From: Sue Howell
Sent: 13 July 2017 14:48
To: Planning.Responses
Cc: Claire Potts
Subject: RE: Planning Consultation on AL/11/17/DOC

Comment from Greenspace

This application is looking for the discharge of Condition 12 of application AL/11/17/DOC imposed under AL/39/13 Landscaping.

APPLICATION NO: AL/11/17/DOC

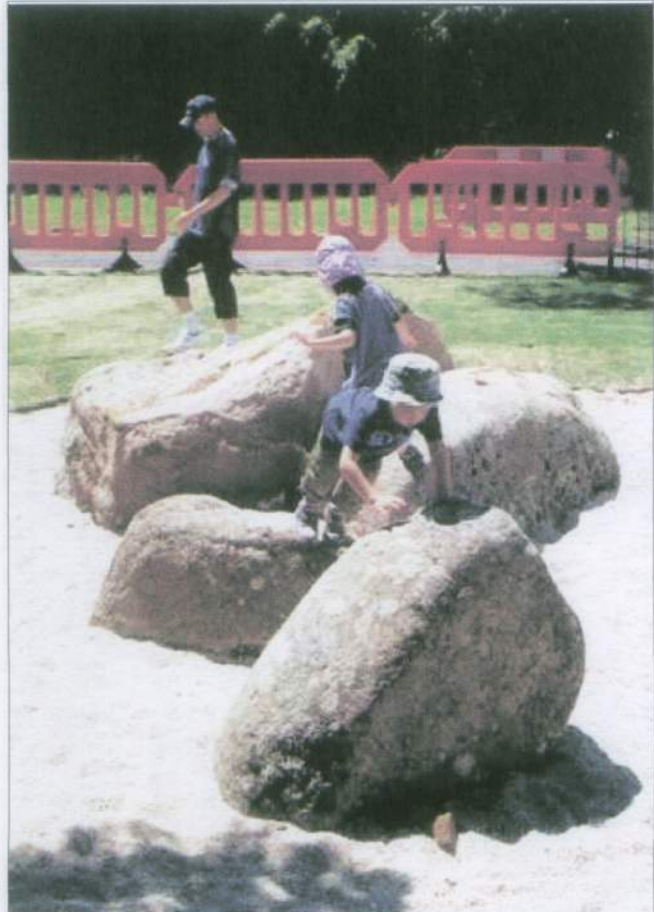
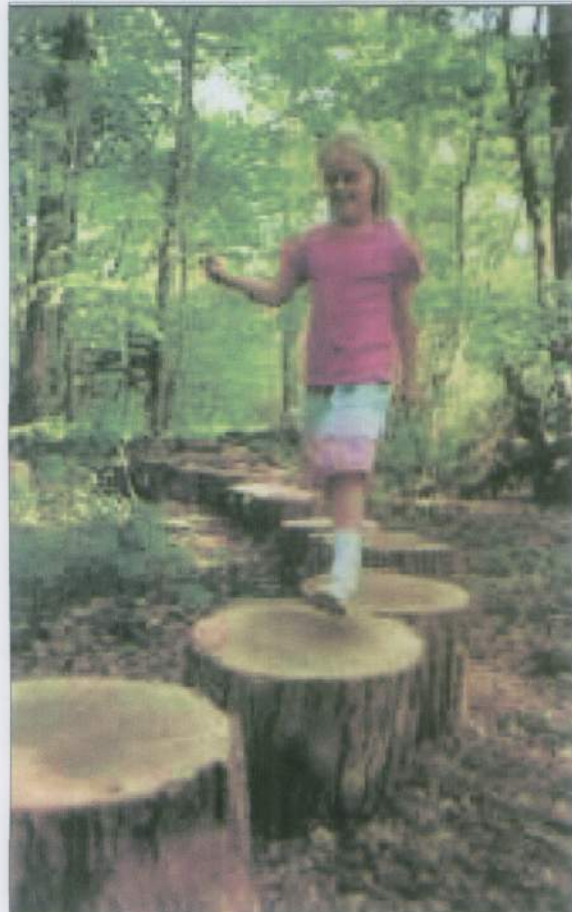
The information provided in substitute landscape proposal plans BDWS20440 11G sheets 1-4 do contain a well thought out scheme which is suitable for location and which is sufficient in detail in plan form. However the open space areas plan 160104/OS Rev C and substitute detailed play area proposals dwg BDWS 20440 20B conflict with these drawings in that they show a different location layout. We would recommend that the open space and play drawings are amended to show the correct layout and how these connect with the pathways which the information lacks at present. We note the proposal to fence the play area because of the proximity to balancing pond and would again recommend that this subject to a ROSPA inspection.

We would therefore **not recommend the discharge of Condition 12 until the play detail plans have been updated and submitted for approval.**
